KITTITAS COUNTY

DEPARTMENT OF PUBLIC WORKS

MEMORANDUM

TO: All Staff
FROM: Public Works Plan Review Team
DATE: July 22, 2021
SUBJECT: 5th County Review of Final Cluster Plat LPF-20-00005 (Forest Ridge Ph1)

FOREST RIDGE - PHASE I PERFORMANCE BASED CLUSTER PLAT		
PREPARED FOR FRPP PHASE I, LLC A PORTION OF SECTION 24, TOWNSHIP 20 NORTH, RANGE 15 EAST, W.M.		
KITITAS COUNTY	DATE	JOB NO.
DWN BY T.S.	05/2021	18069
CHKD BY M.K.K./D.L.P.	SCALE 1" = 100'	SHEET 5 OF 7

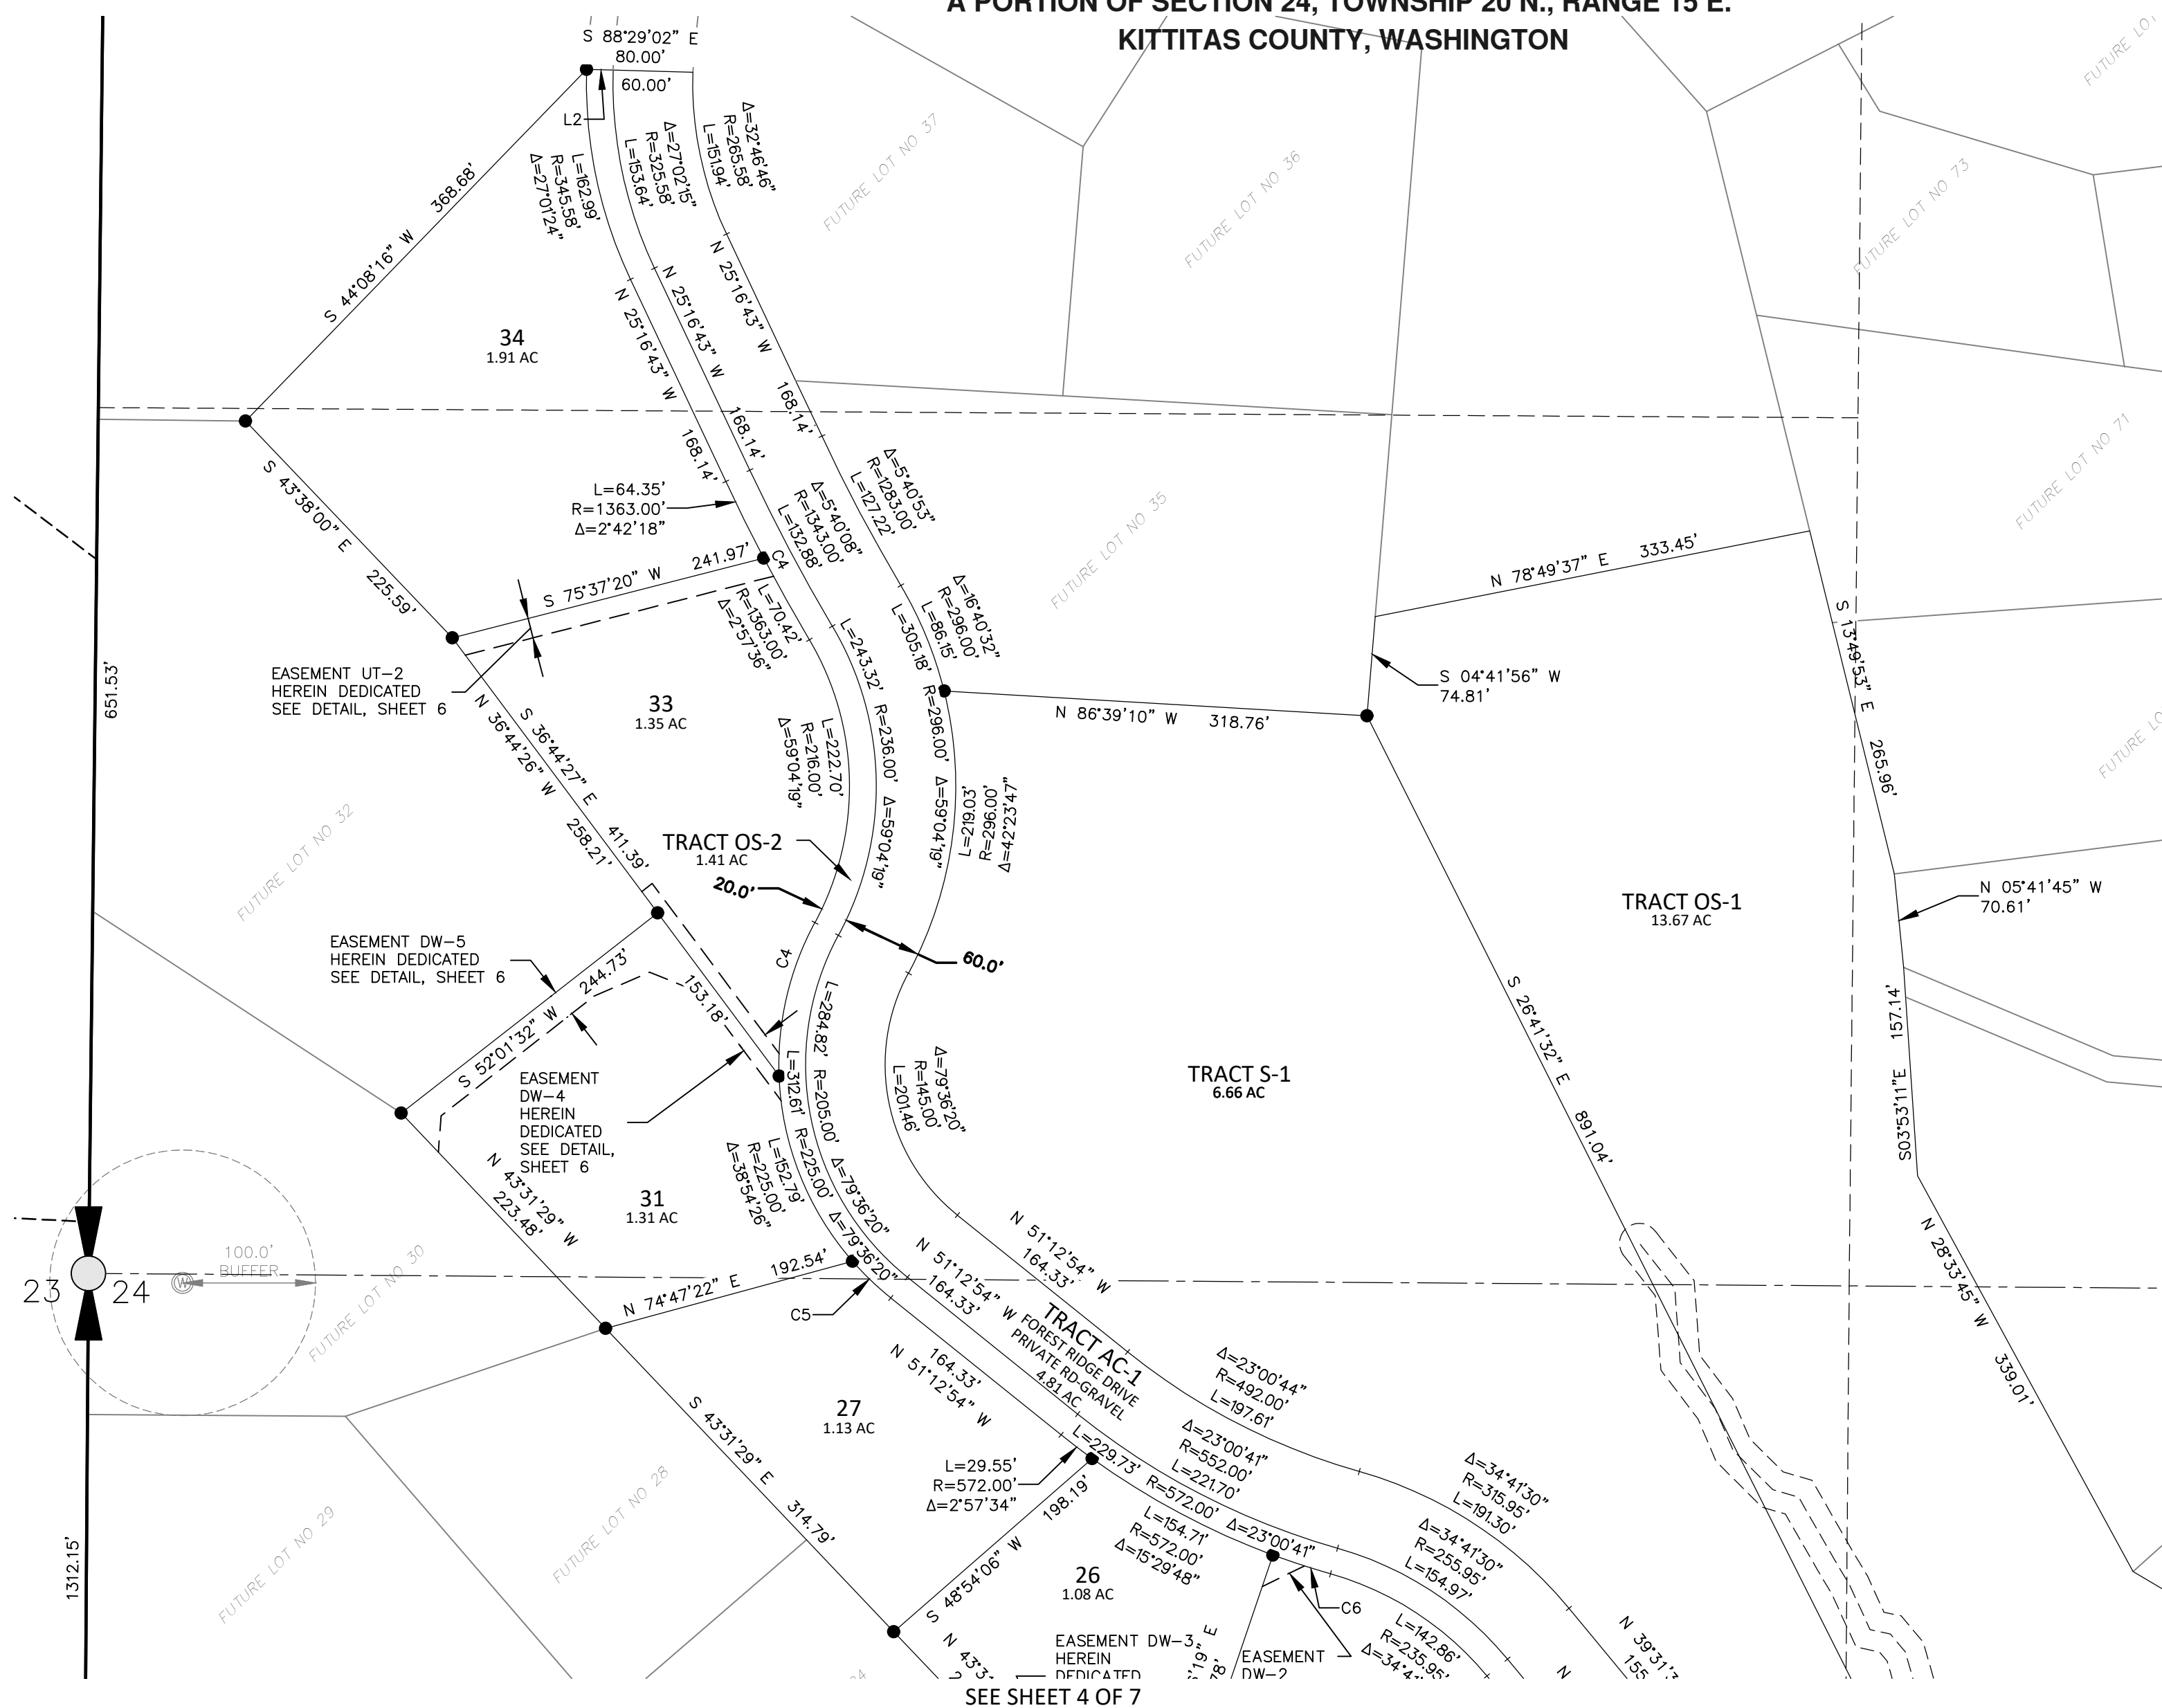
1. There is a small discrepancy between the plat and the closure report for Tract FD-1.
2. Plat note 8 calls for snow storage areas identified on the face of the plat. There are no such areas designated.
3. Sheet 4 does not show any property corners set.
4. The SW line of Lot 33 shows two different bearings for the same line.
